Office of Environment & Heritage

DOC18/675268

RE: Eurobodalla Southern Storage Project SSD 7089 – Notice of Exhibition

Attachment A – Detailed comments on Biodiversity matters

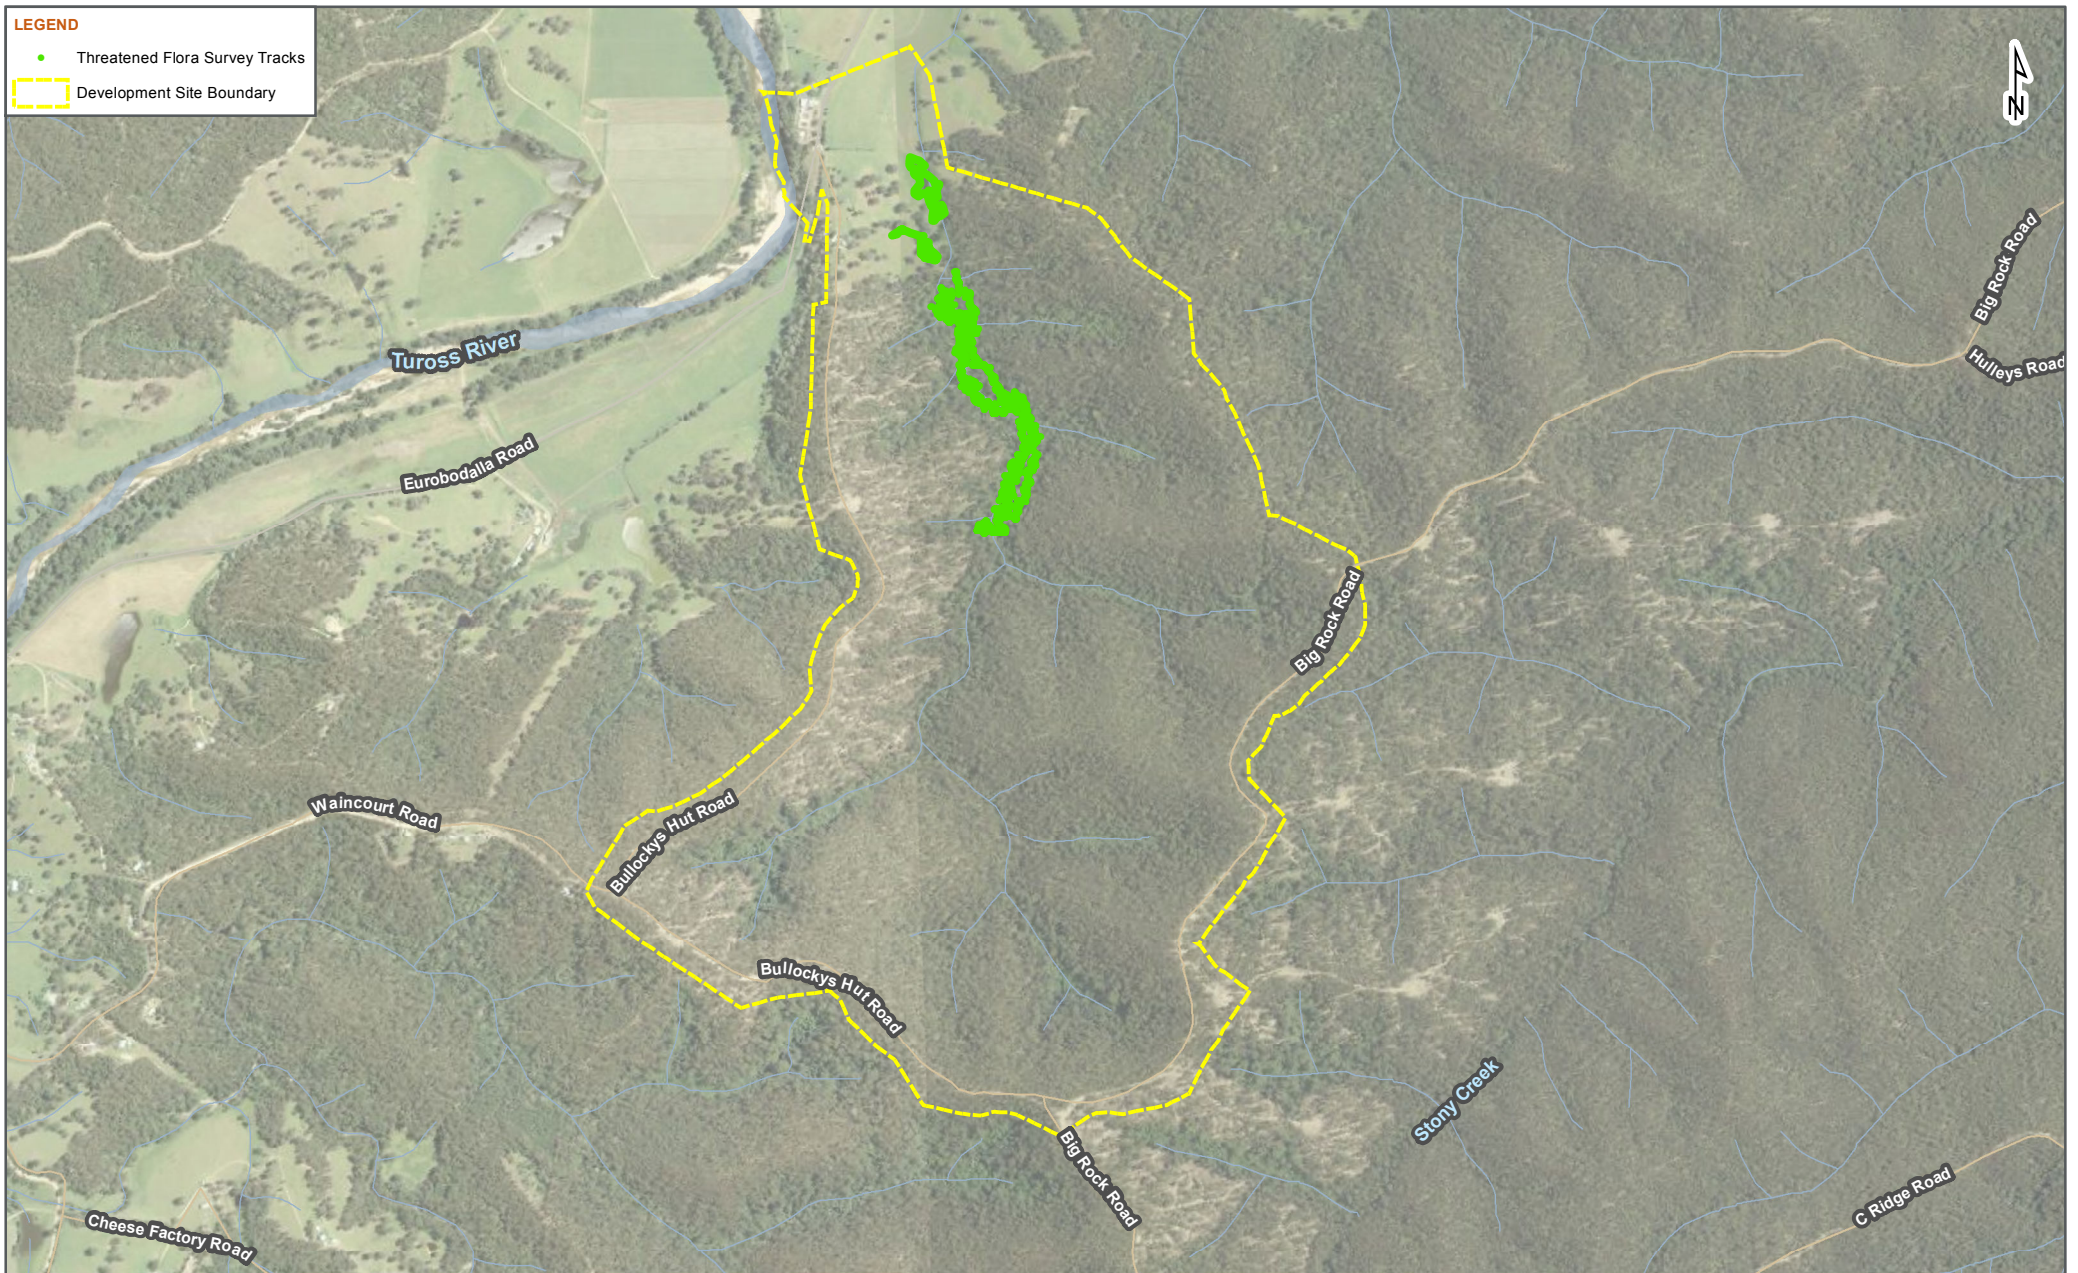
- The location of targeted flora and fauna survey sites do not appear stratified, and appear to fall primarily outside of the main impact site. This means that threatened species that may be present would not have been detected in the impact area and will therefore not be offset.
- The frog and pygmy possum surveys that were completed are described in the SMEC *Biodiversity Assessment Report* as having been conducted in sub-optimal conditions and cannot therefore be relied upon.
